From: Mike Burford**Sent:** 14 February 2012 16:17**To:** Planningecons**Subject:** RE: Planning Consultation on: LU/5/12/

Engineers Surface Water disposal comments on LU/5/12/:

APPLICATION LU/5/12/

Description of Works: Erection of 1 no. 3 bed town house

## BLOCK PLAN

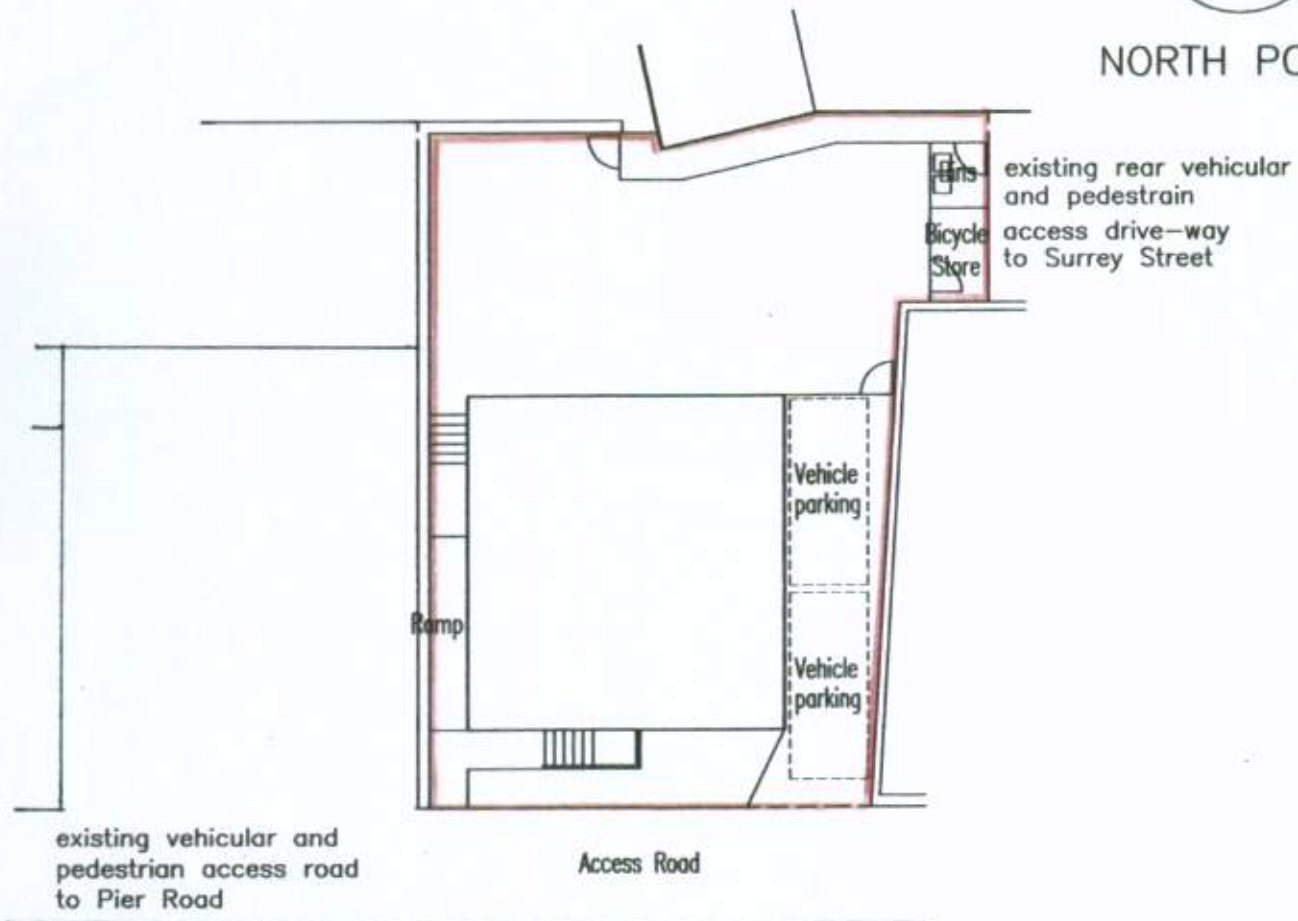
The site being small and built upon on all sides may not be able to be suitably drained using soakaways. I would advise that the applicant seeks Southern Waters permission for discharge into the public surface water sewer in the main road.

Development shall not commence until full details of the proposed surface water drainage scheme have been submitted to and approved in writing by the Local Planning Authority.

No building shall be occupied until the complete surface water drainage system serving the property has been implemented in accordance with the agreed details.

Winter groundwater monitoring to establish highest winter ground water levels and Percolation testing to BRE 365, or similar approved, will be required to support the design of any Infiltration drainage.
